Development Control
Ribble Valley Borough Council

App no: 22.0983

Address: Former Public Toilets Market Place Longridge

The submitted documents and plan 'Proposed site plan' JM-0254-003-Rev A have been reviewed and the following comments are made.

PROPOSED SITE PLAN

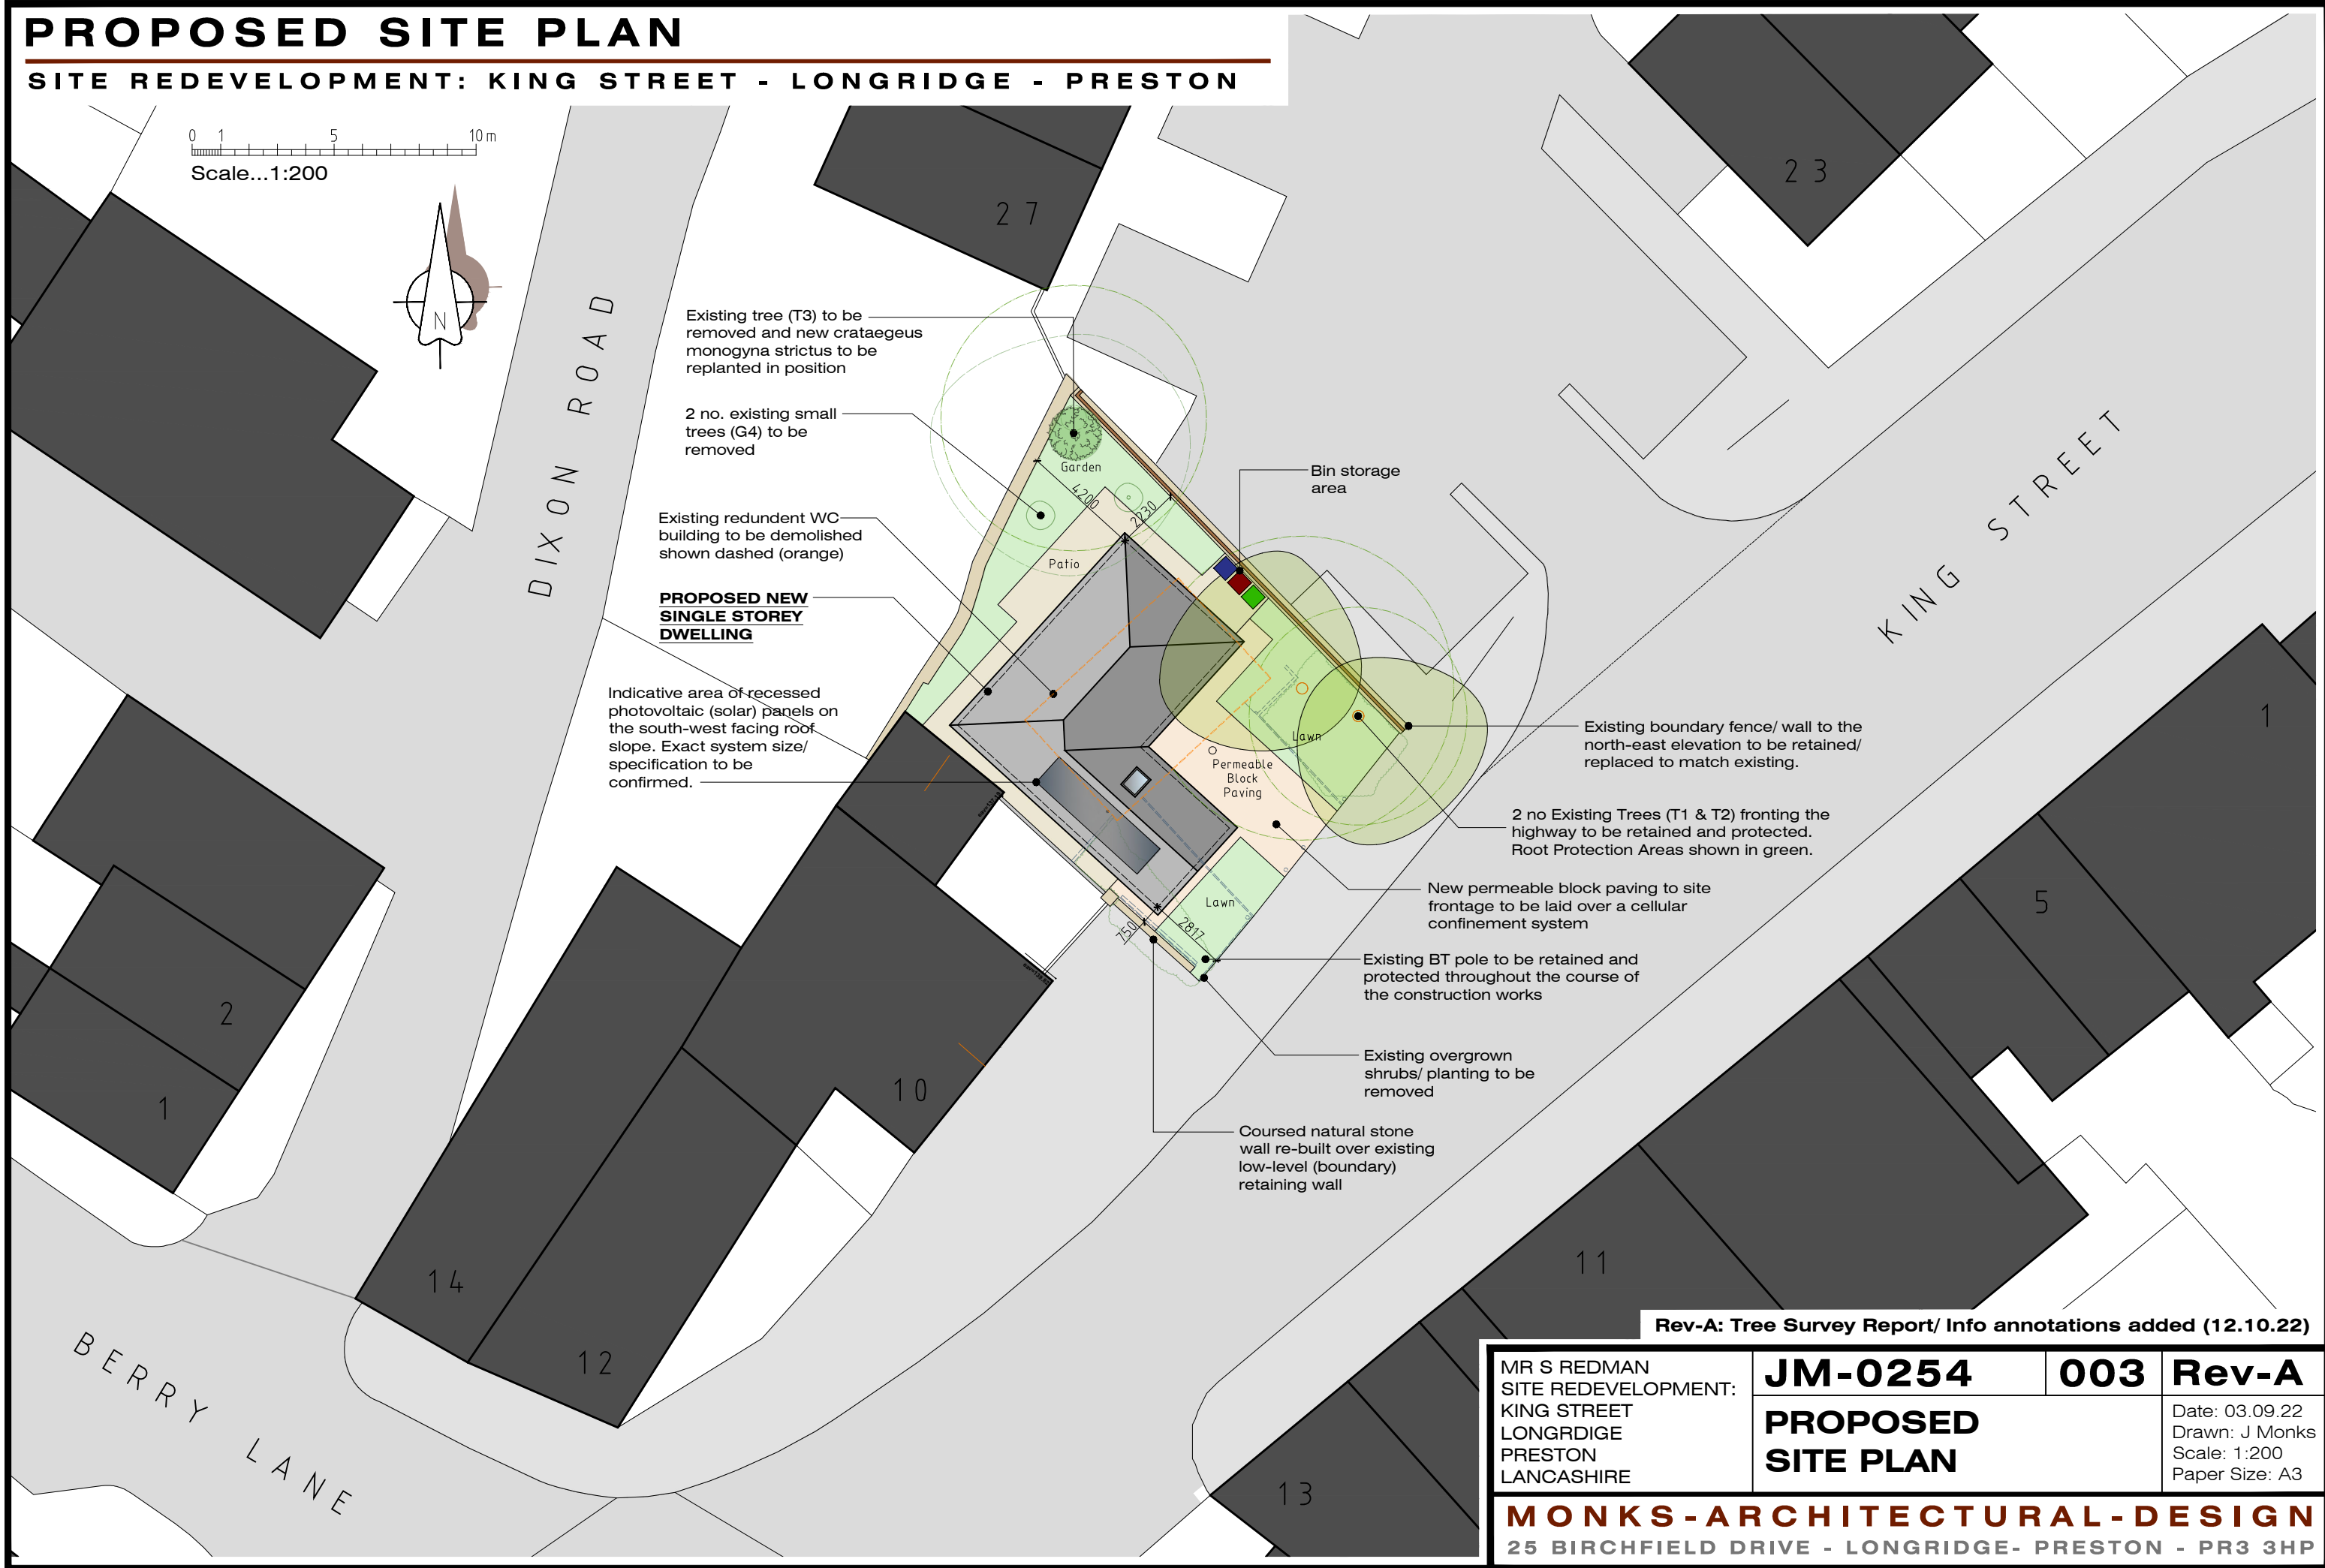
The site plan proposes a block paved car parking space measuring 6.4m long by 2.6m wide. The size prevents the vehicle from being able to turn and exit onto Market Place in forward gear. The paving is bound and porous and is considered acceptable.

This will require a new vehicle crossing on Market Place B5269 which is subject to a 30mph speed limit. There is a surface water road gully along the frontage of the site.

The vehicle crossing causes conflict with the adjacent road junction and bus stop, where the kerb tapers across the development site. The single parking space will require a reversing manoeuvre on the adopted highway which is a classified road carrying a significant volume of traffic of approximately 8000 vehicles a day, with a high percentage of heavy vehicles of approximately 8%.

The Highway Authority would object to the new vehicle crossing required for the car parking space at this location due to conflict with highway users on a busy section of classified road.

Should the application be considered for approval we would require the off-street parking bay, accessed from Market Place, removed from the scheme and a secure, cycle store being provided.

The site is located within walking distance of mainline bus services and local facilities and could support residents without a car. However, we would seek to secure a car parking place and electric vehicle charging point at the dwelling with a potential alternative point of access on King Street, which is adopted highway.
